KITTITAS COUNTY DEPARTMENT OF PUBLIC WORKS

MEMORANDUM

TO: All Staff
FROM: Public Works Plan Review Team
DATE: June 6, 2024
SUBJECT: BL-24-00009 Trust for Public Lands

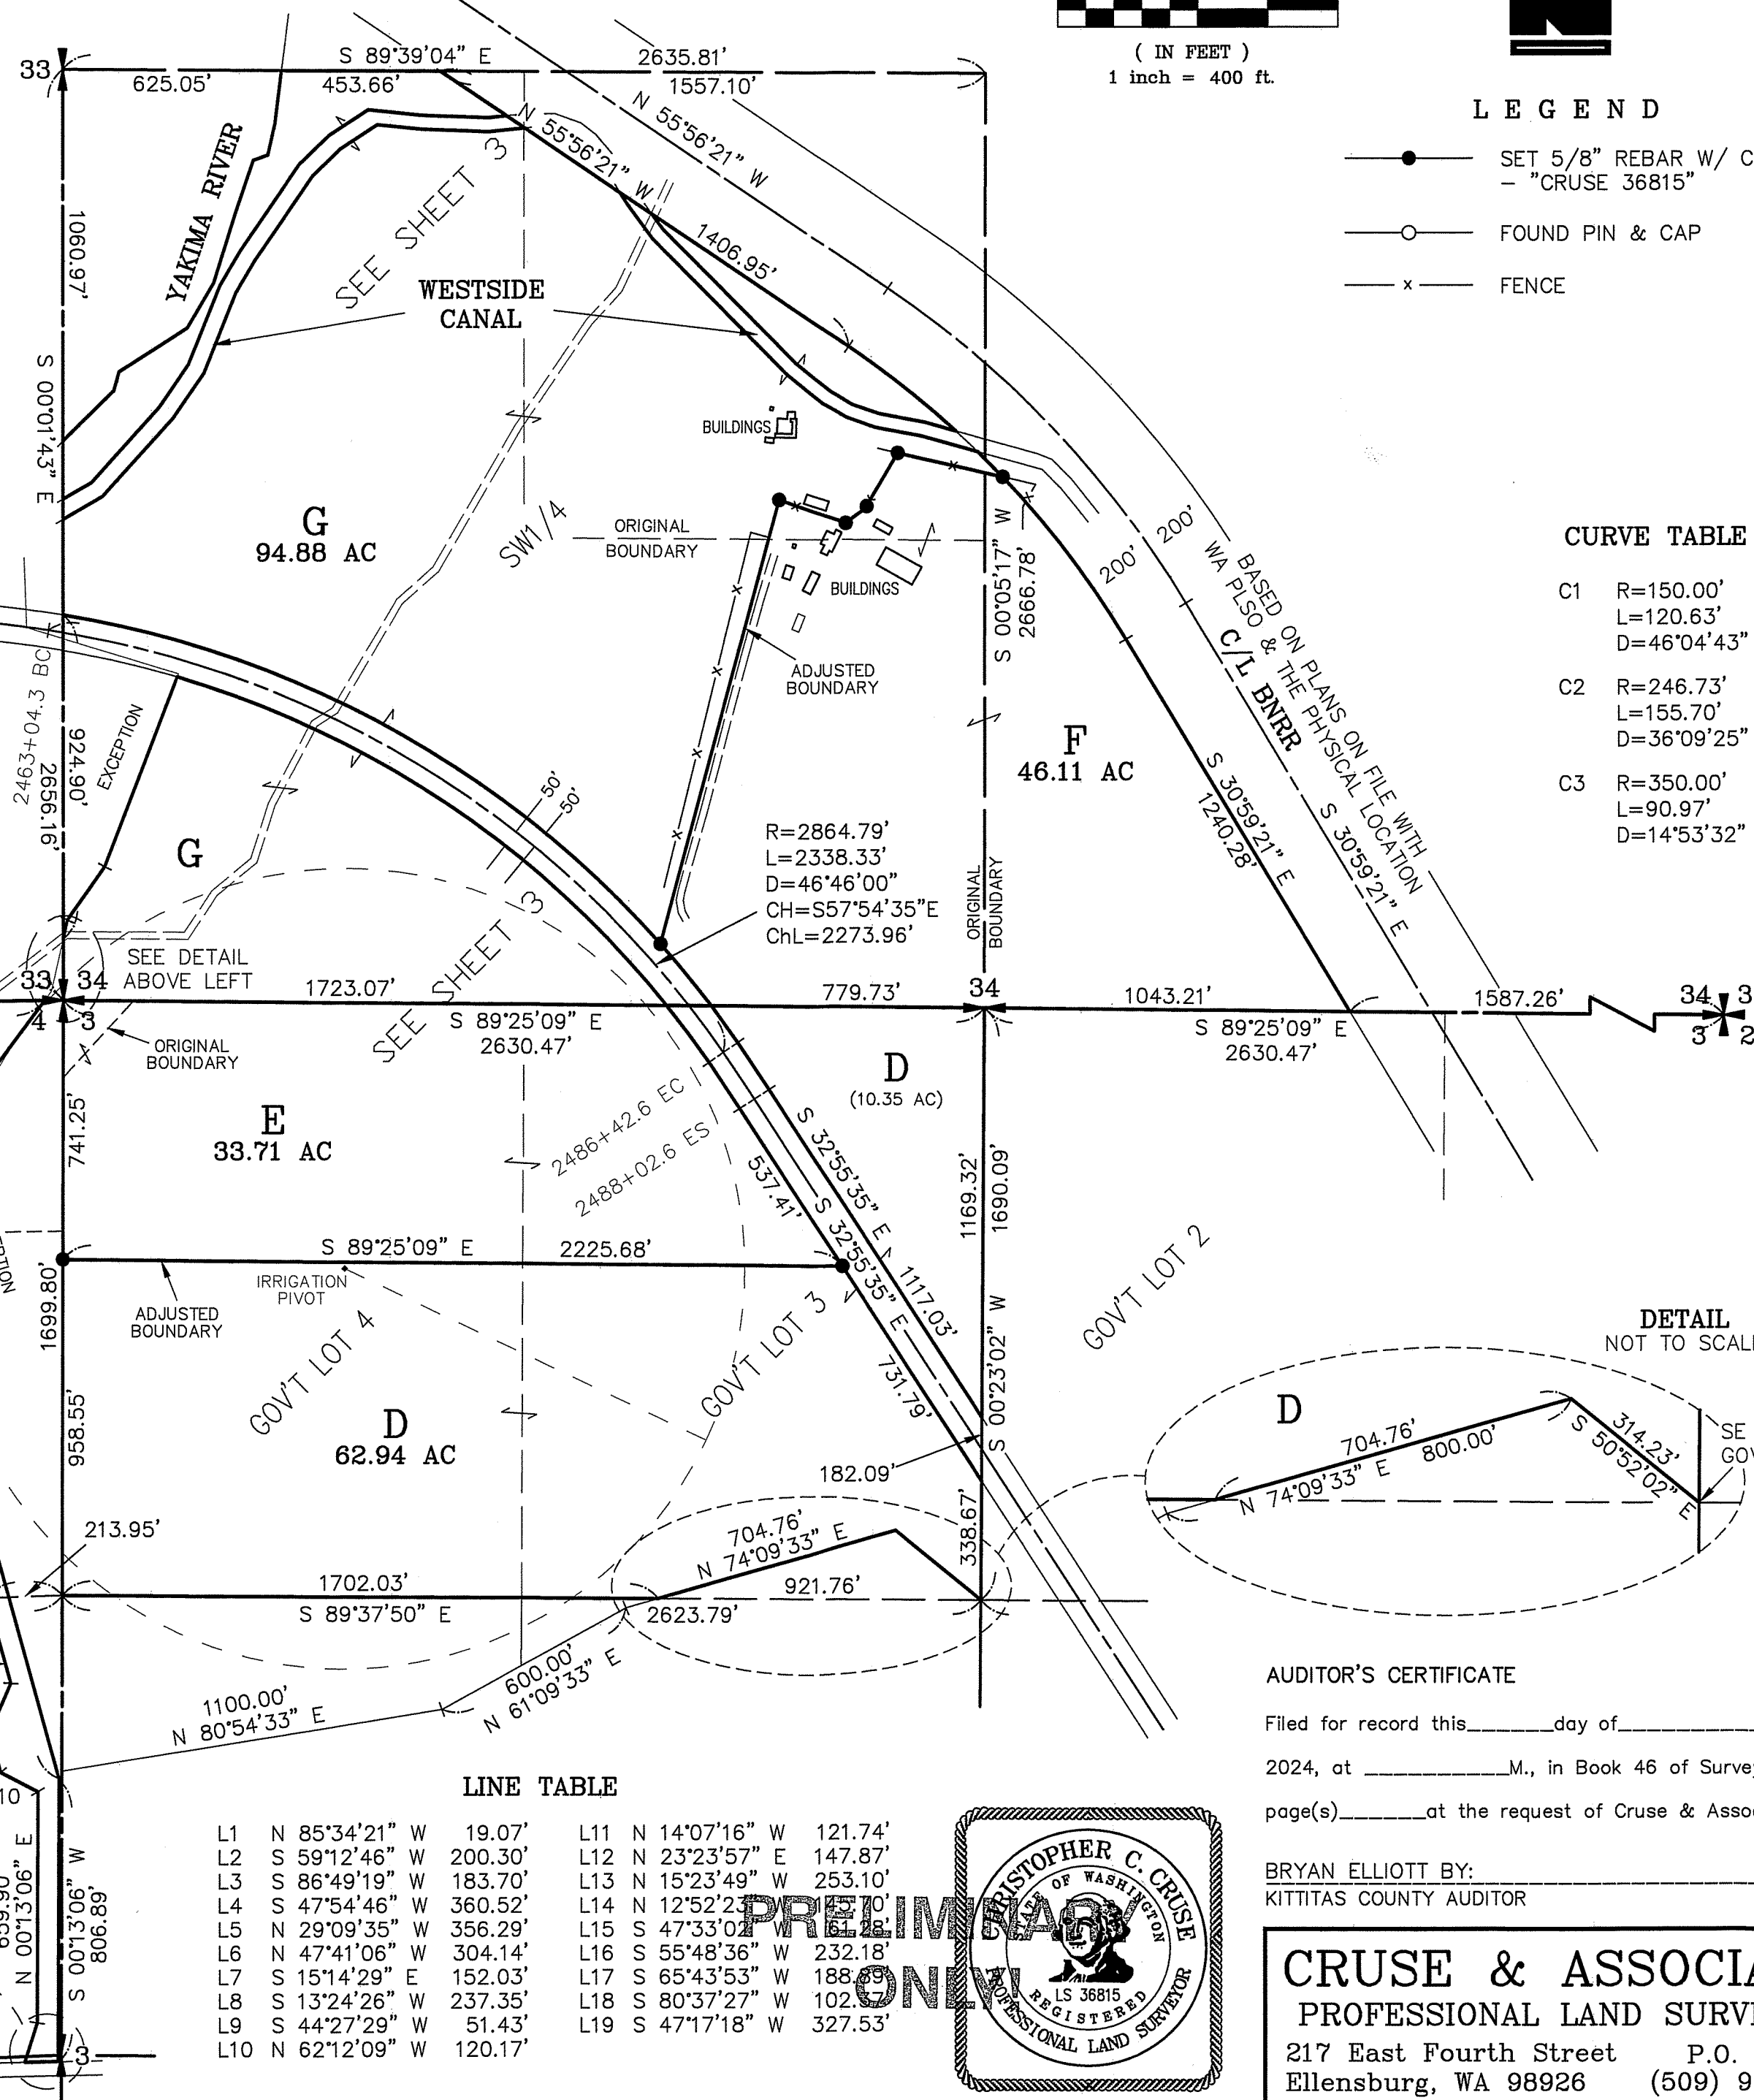
SURVEY	As the application does not contain a survey map, comments are reserved until final. (KAH) UPDATE 08/14/2024 1. The West boundary of Parcel G, N of John Wayne Trail is shown as 220.96', rather than the distance per closure report of 271.63'. Additionally there is a "tick" or "crowsfoot" here that appears to be incorrect. 2. The SW boundary of Parcel F has a type in the Chord Length (289.41 vs 229.41). 3. For the Westside canal, please reference the document(s) that do not show the width of the R/W. 4. Please confirm that the building located near the E edge of Parcel G meets 25' front yard setback from proposed property line? 5. Where spirals are shown, sufficient information to recreate the spiral at centerline will need to be provided. In instances where BS,BC,EC, and ES can be used to determine spiral length, the only thing that would need to be included would be the spiral rate of change ('a' value). For offsets to c/l spiral (edge of R/W), nothing additionally is needed. 6. At a minimum, the new division lines will need to be staked in the field and corners shown on the face of the map. Where the new property corner is coincident with a missing section corner, a survey marker stamped in accordance with the Manual of Survey instructions shall be set. 7. The Original Parcel Descriptions do not match the title report. While referencing a document of record is acceptable, this attempt goes so far as to essentially create a new legal description. Legal descriptions should be a direct reference to a document of record or written out in full. Whichever option is utilized must match the title report. (JT) UPDATE 09/16/2024 The most recent update has addressed all prior survey comments except Note 4. The building referenced in Note 4 is being dealt with between CDS and the Yakama Nation. No additional requirements will be needed to be shown on the face of the survey map. (JT)
